**Item No.** Report of the Head of Development Management and Building Control

**Address:** 201 FIELD END ROAD EASTCOTE PINNER

**Development:** Installation of a new fabric canopy to shopfront.

**LBH Ref Nos:** 3742/APP/2025/1297

REFERENCE  
FE-1504-EPES

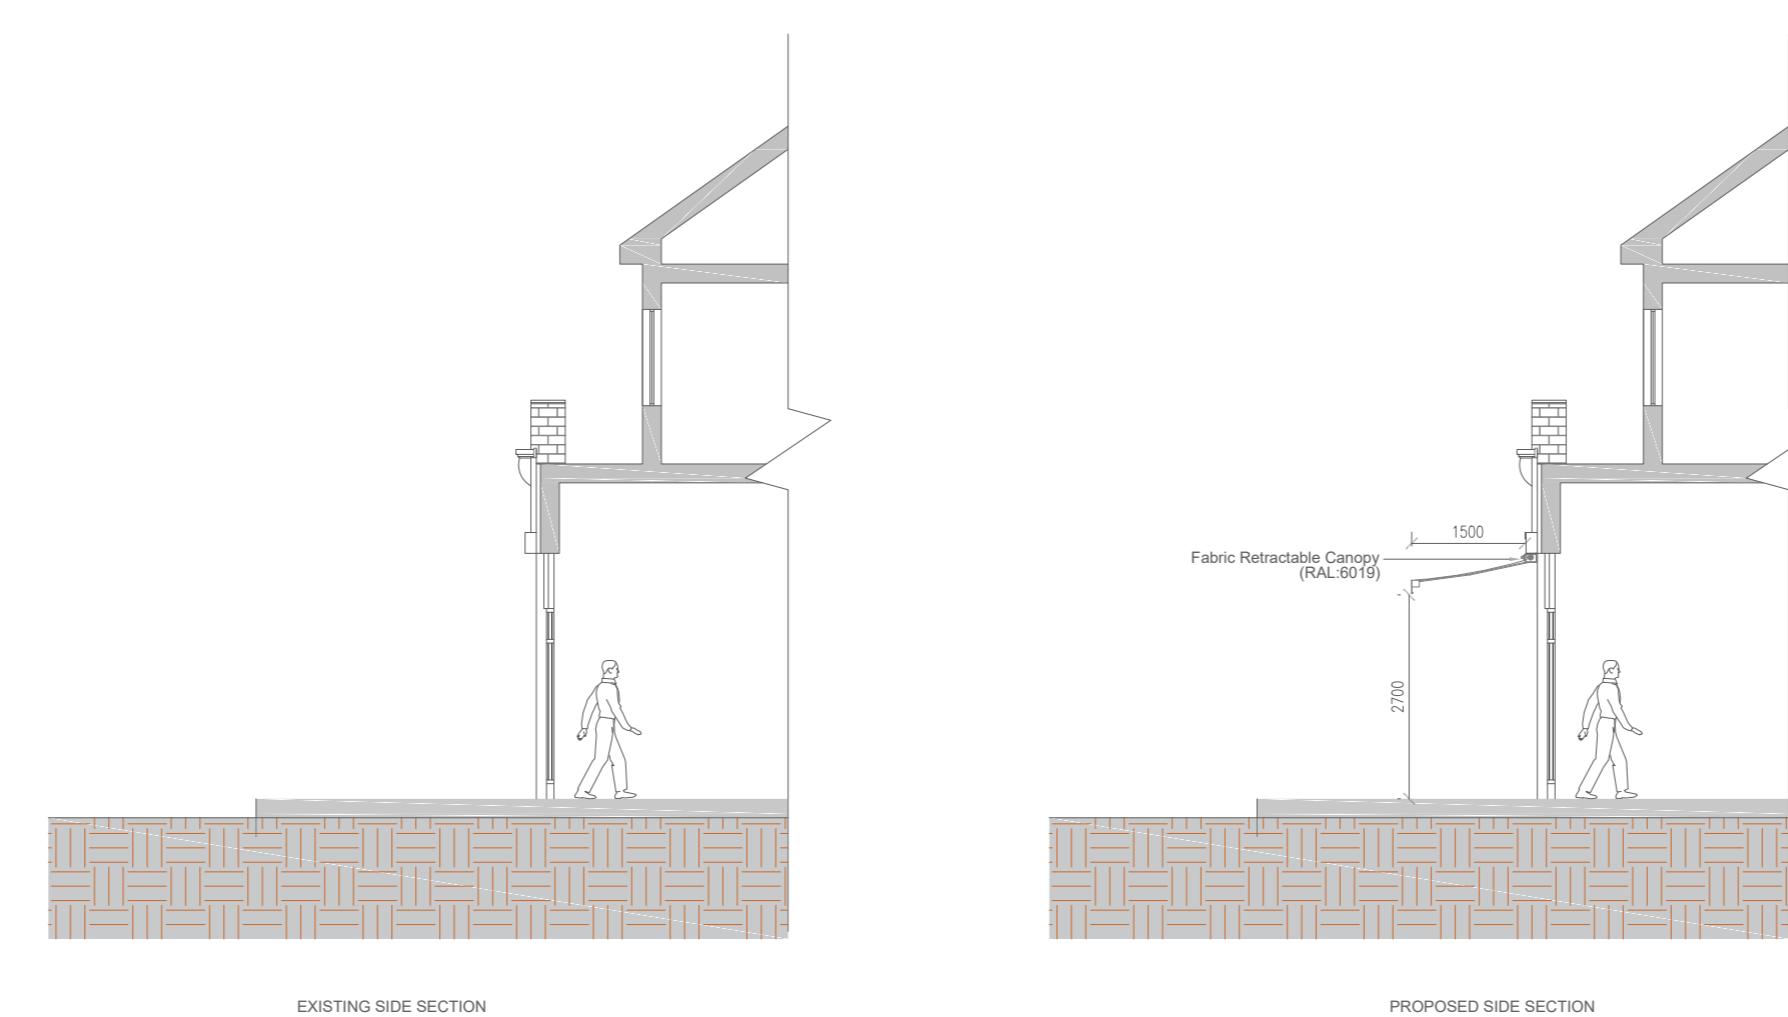
The application seeks planning permission for the installation of a new retractable fabric canopy to be sited above the bakery/patisserie shopfront. The awning would extend up to 1.5m over the public footpath and would have a minimum height of 2.7m from the footpath, leaving sufficient space for passersby to walk underneath.

The canopy would be green in colour to match the existing green colour of the shop front, which is supported, ensuring the canopy remains in keeping with the existing building.

The Council's Access Officer has been consulted on the application. They stated that the 2.7m minimum height of the canopy from the footway would be sufficient to continue to allow for unimpeded access along the footway. They did not raise any concerns or objections
